RE: MP 09_0146 MOD 1 – EAST LAKES SHOPPING CENTRE

Thank you for your letter received 8 August 2017 regarding the proposed modification to the Eastlakes Shopping Centre, Eastlakes (DPE Ref: MP 09_0146 MOD 1).

Clare Harley
Manager Strategic Planning

3 PLAN Typical L2-L6  
1:100

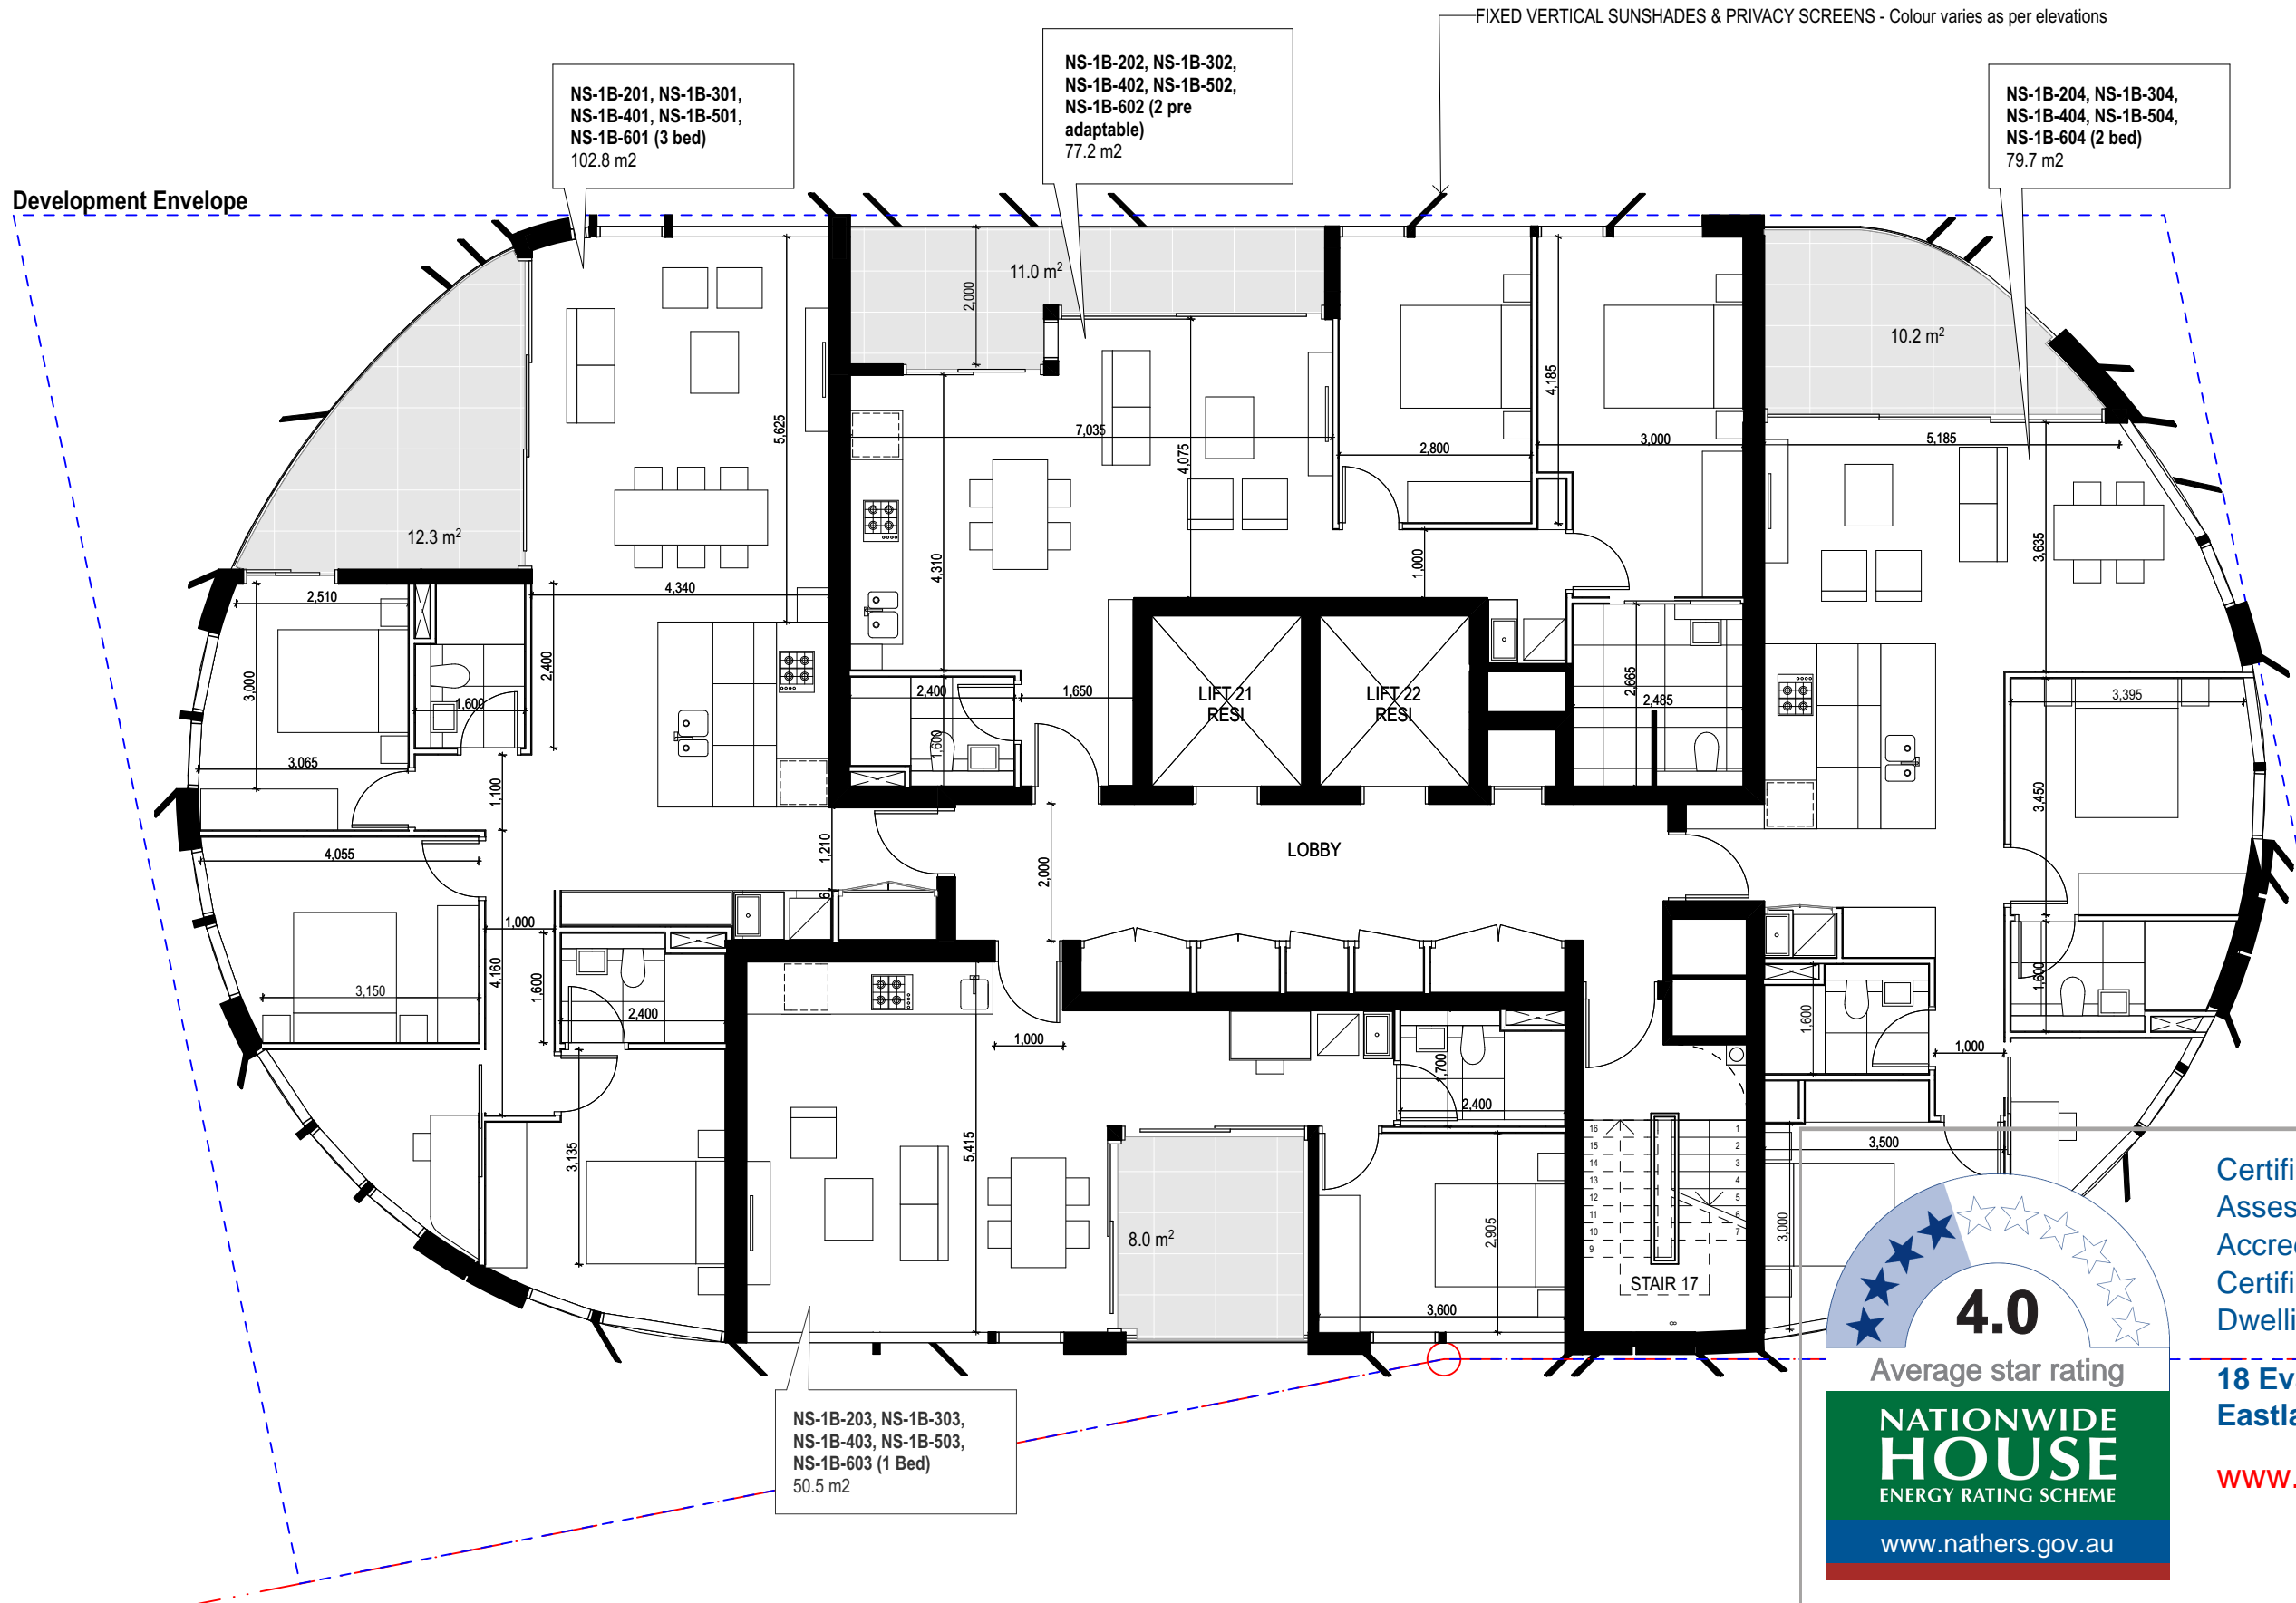
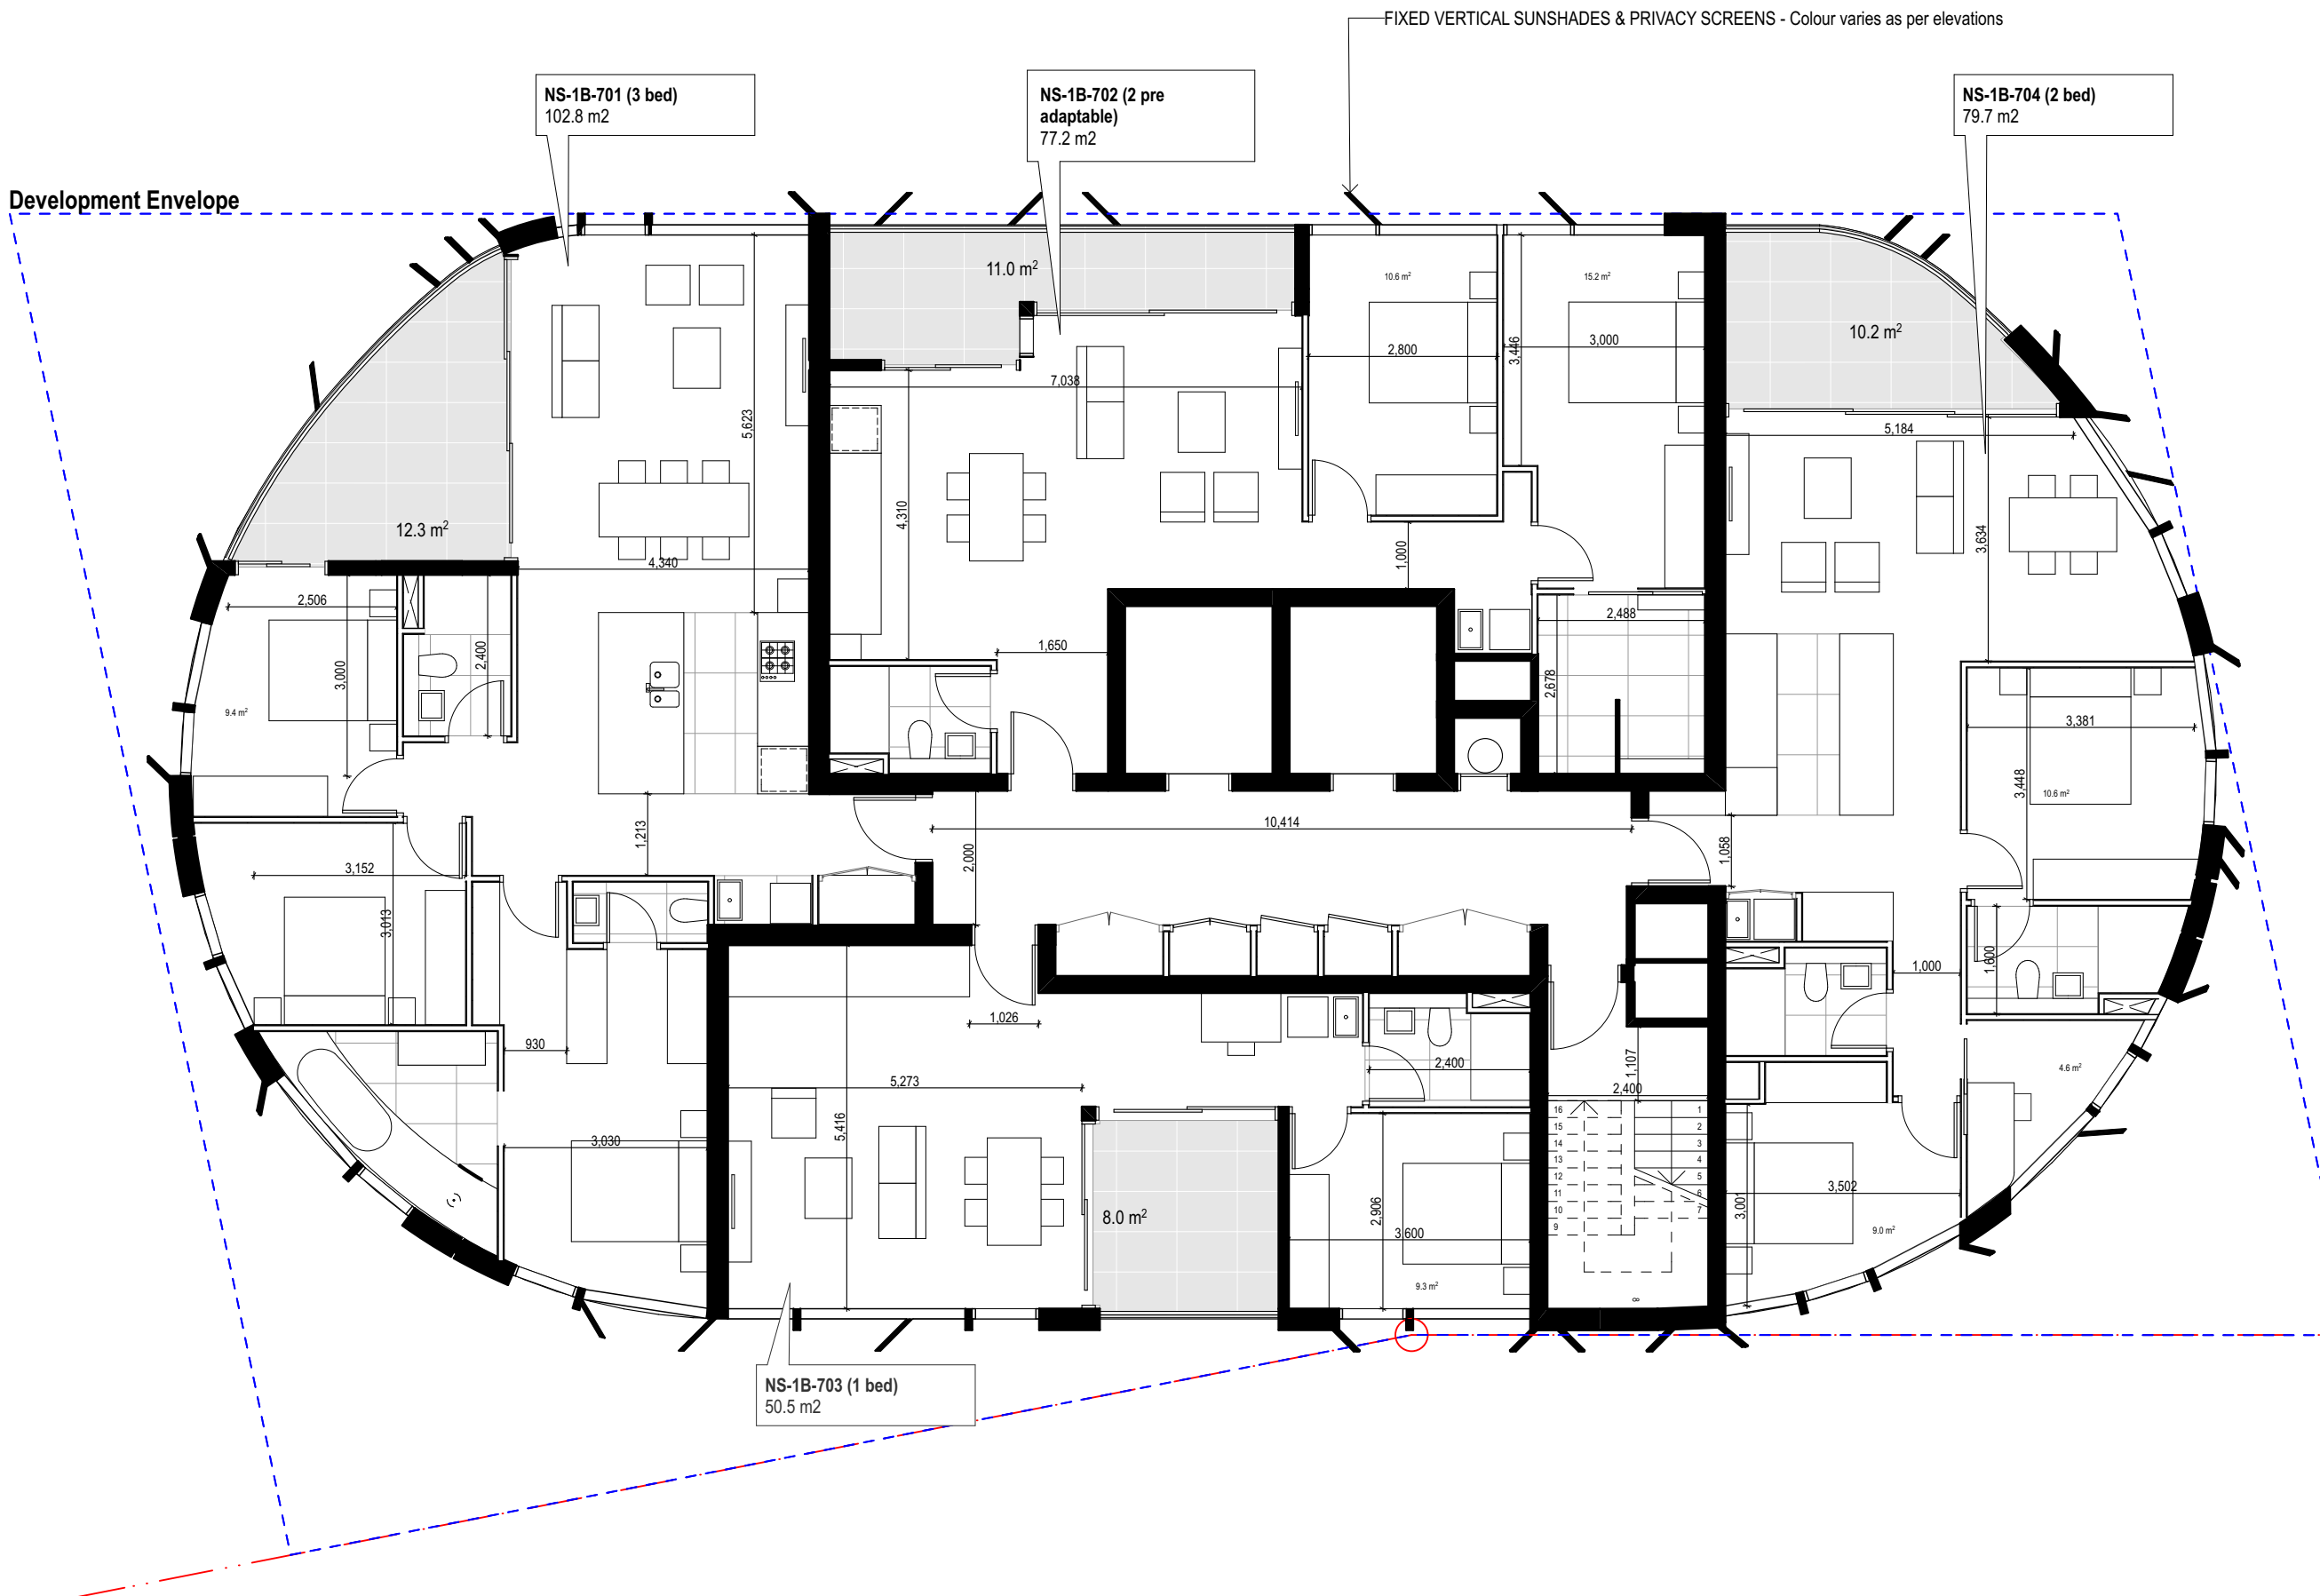
It is noted that the proposed modification to Building B1 would result in non-compliance with the building separation distance required by the Apartment Design Guide (ADG). Consideration should be given to either a revised building design to achieve compliance; or the inclusion of adequate mitigation measures in the design to ensure that the amenity of adjoining residential development is not unreasonably impacted.

All 3-bedroom apartments in Building B1 are to demonstrate compliance with *Part 4C.4.2 - Family Friendly Apartment Buildings* of the Botany Bay Development Control Plan 2013 (BBDCP 2013).
